Our Ref: ID 3907
Your Ref: SSD-80441462

24 June 2026

Waterloo Mixed Use Development 881-885 Bourke Street (RTS)

Thank you for the opportunity to provide advice on the Response to Submissions (RtS) for the proposed Waterloo Mixed Use Development at 881-885 Bourke Street. It is understood that the proposed development seeks to develop 9 residential and mixed-use buildings across four development parcels, and changes to the proposal since the EIS stage include:

Figure 23 *Flood Hazard PMF with Climate Change*

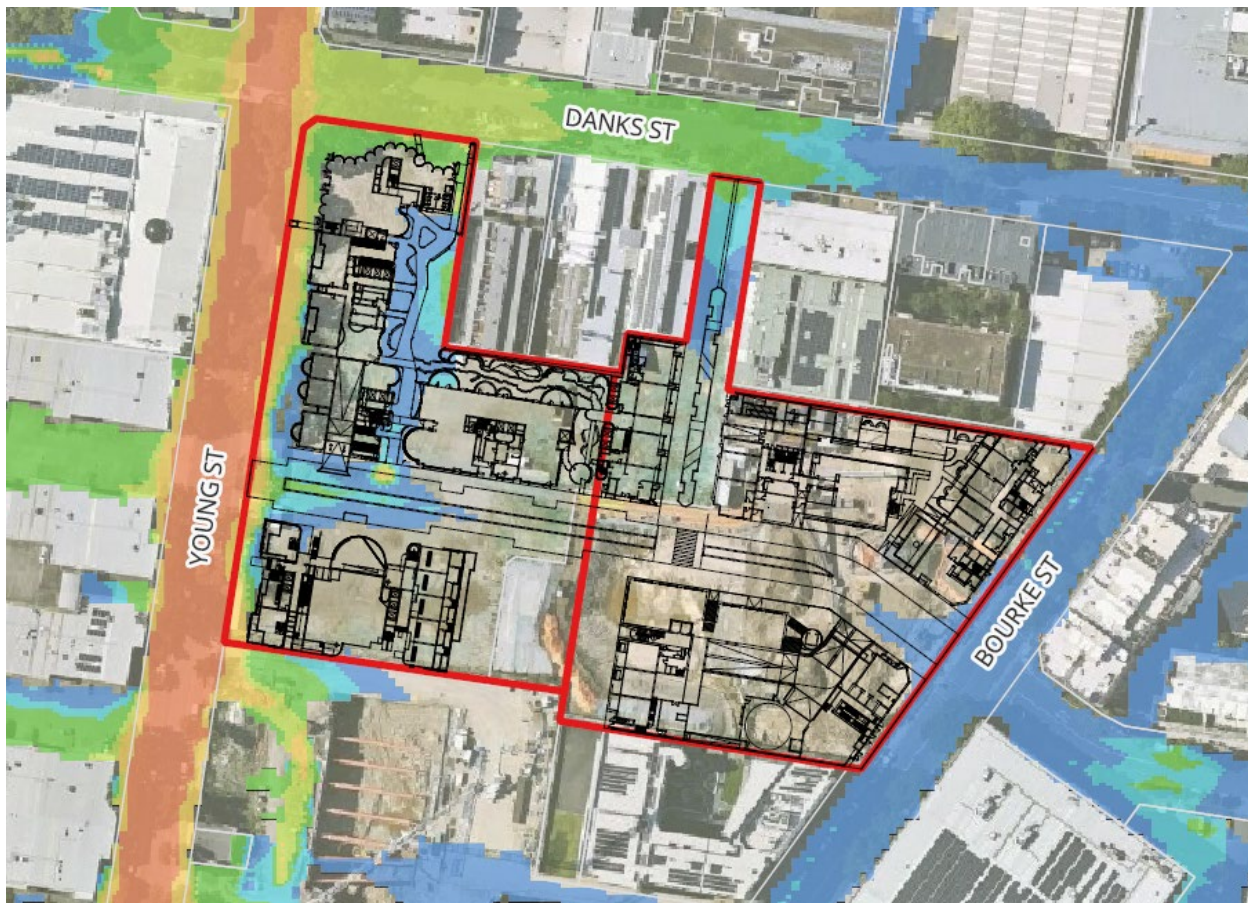
It is noted that the intersection of Young St and Danks St becomes inundated prior to a 10% AEP event,⁹ and that the site itself is prone to flooding in a PMF event with hazards of up to H5 flooding directly adjacent to the proposed buildings along Young Street.¹⁰ This hazard is unsafe for all people and vehicles, and any buildings exposed to this hazard are vulnerable to structural damage.¹¹

Figure 24 Emergency Egress Route

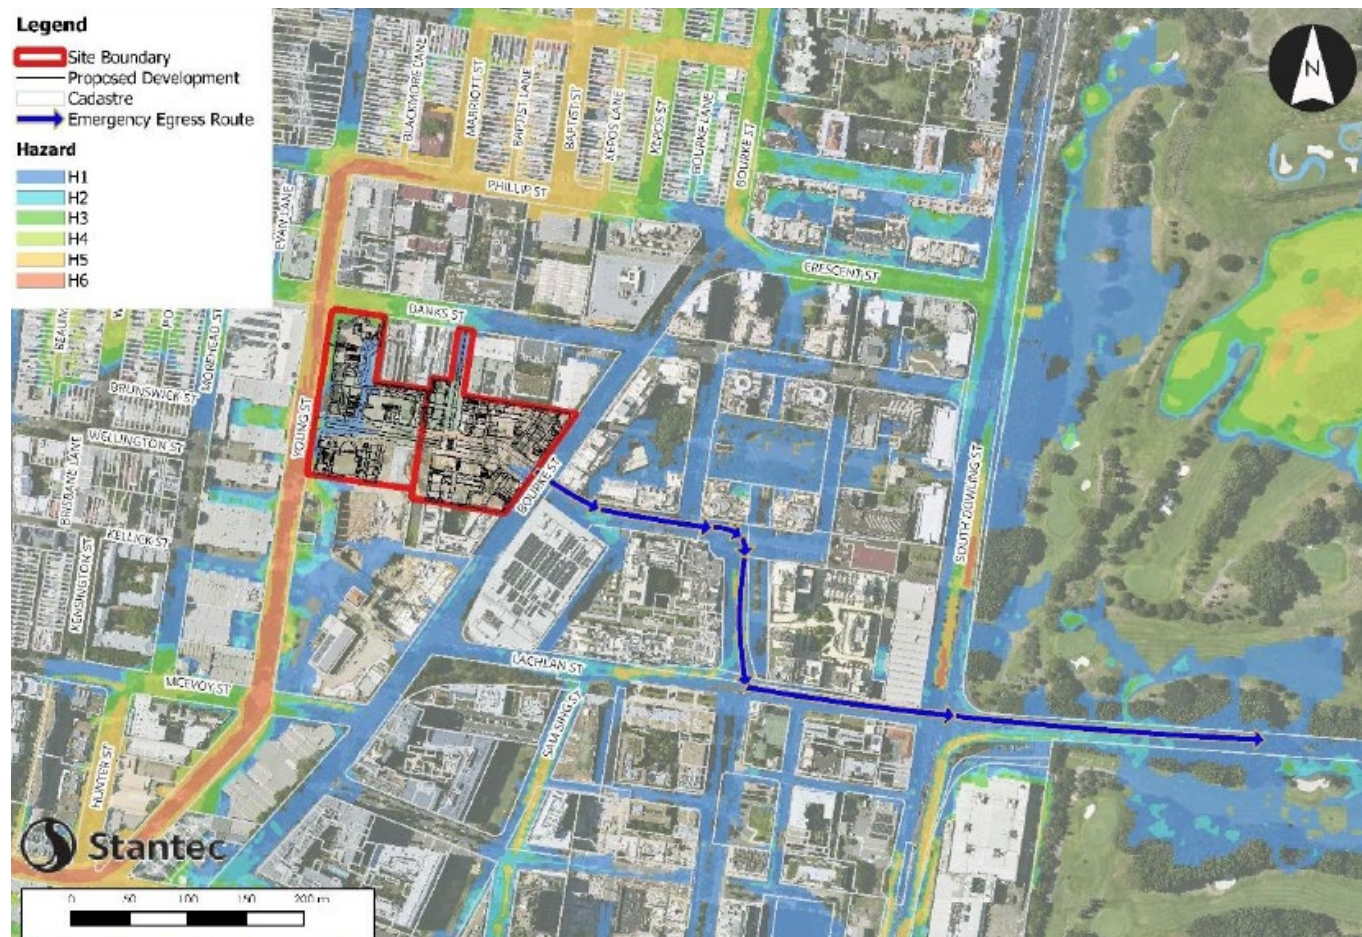
We appreciate that the proposed primary strategy in the FERP has been more clearly clarified and note the FERP states that the suggested road route during flood events is to be for emergency access only. We recommend the following additional changes to the FERP:
